Subject: Rezoning Petition Review

Rezoning Petition #: 22-030

Location of Property: Approximately 0.36 acres located at the southeast intersection of Matheson Ave and Pinkney Ave, west of Clemson Ave.

800 MATHESON AVE - REZONING
 PARCEL ID 0811127
 800 MATHESON AV CHARLOTTE NC 28205
SITE PLAN - REZONING

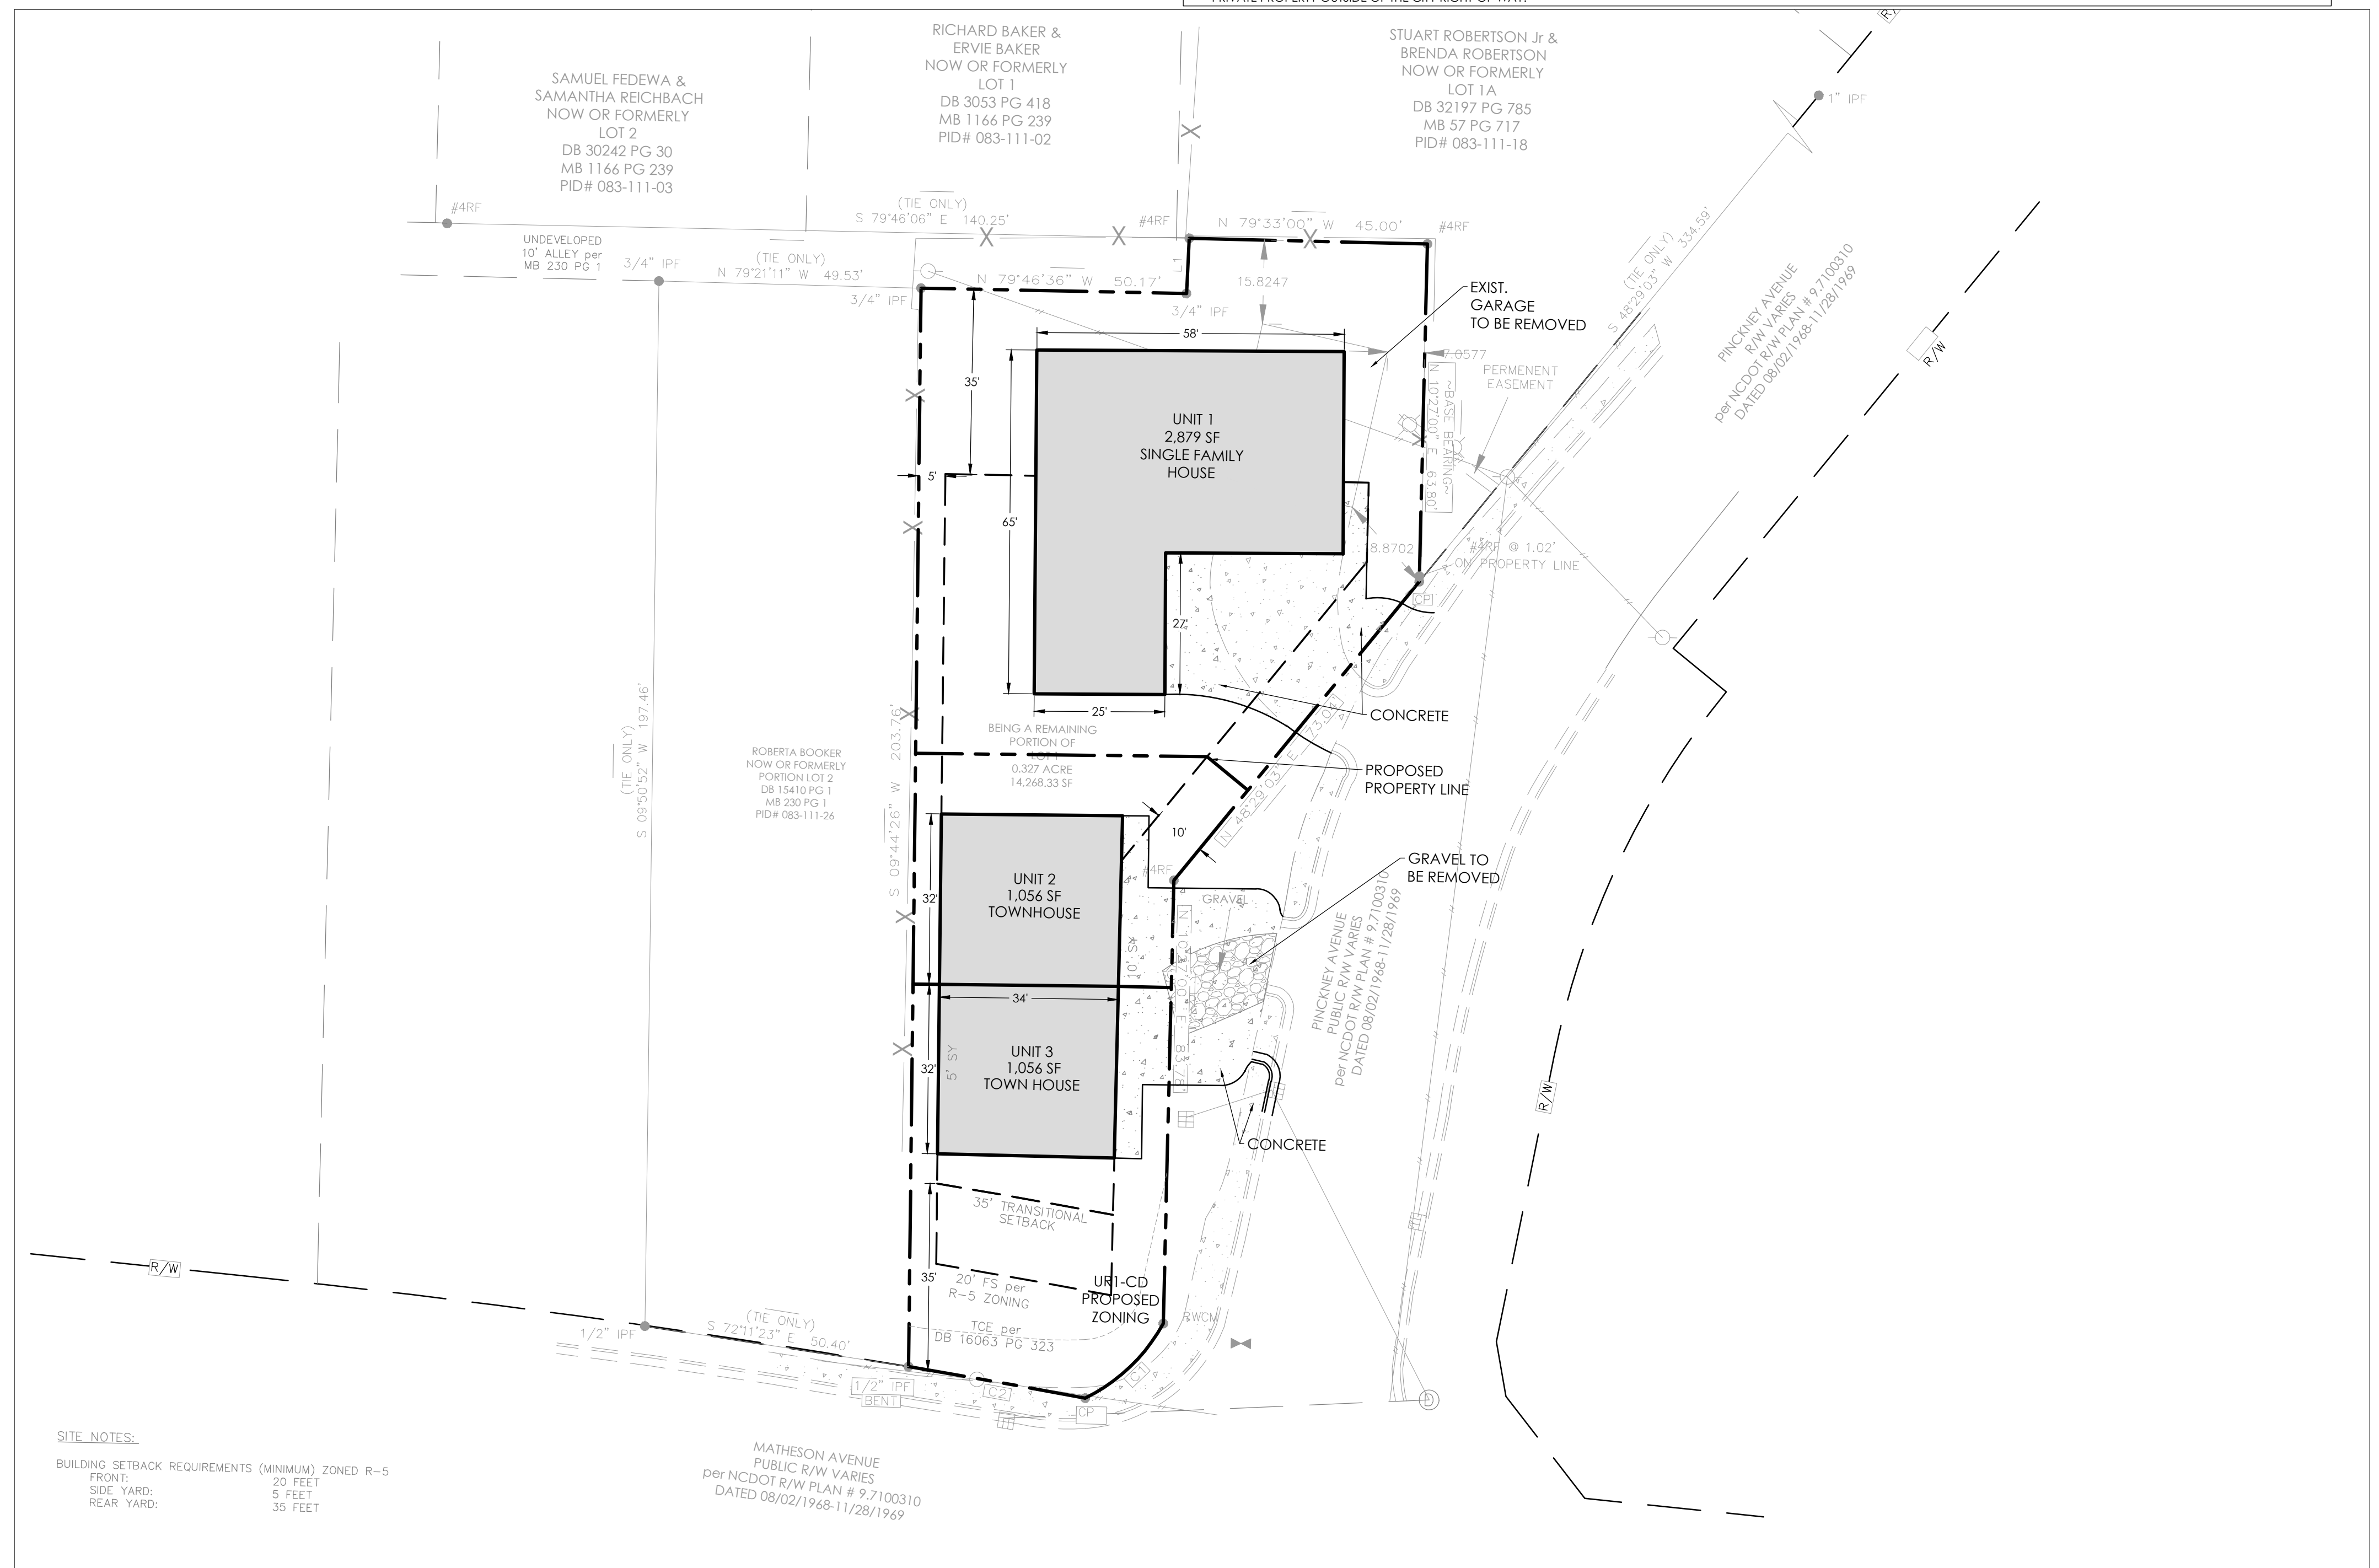
This property drains to Upper Little Sugar Creek, which is an impaired/degraded stream, and may contribute to downstream flooding. This project has the opportunity to mitigate future impacts to this stream, therefore, Storm Water recommends placing the following notes on the plan:

For defined watersheds greater than 24% built-upon area (BUA), construct water quality stormwater control measures (SCMs) designed for the runoff generated from the first 1-inch of rainfall for all new and redeveloped BUA associated with the project. SCMs must be designed and constructed in accordance with the Charlotte-Mecklenburg BMP Design Manual.

For defined watersheds greater than 24% built-upon area, control the entire volume for the 1-year, 24-hour storm for all new and redeveloped BUA associated with the project. Runoff volume drawdown time shall be in accordance with the Charlotte-Mecklenburg BMP Design Manual.

For residential projects with greater than 24% BUA, control the peak to not exceed the predevelopment runoff rates for the 10-year and 25-year, 6-hour storms or perform a downstream analysis to determine whether peak control is needed, and if so, for what level of storm frequency.
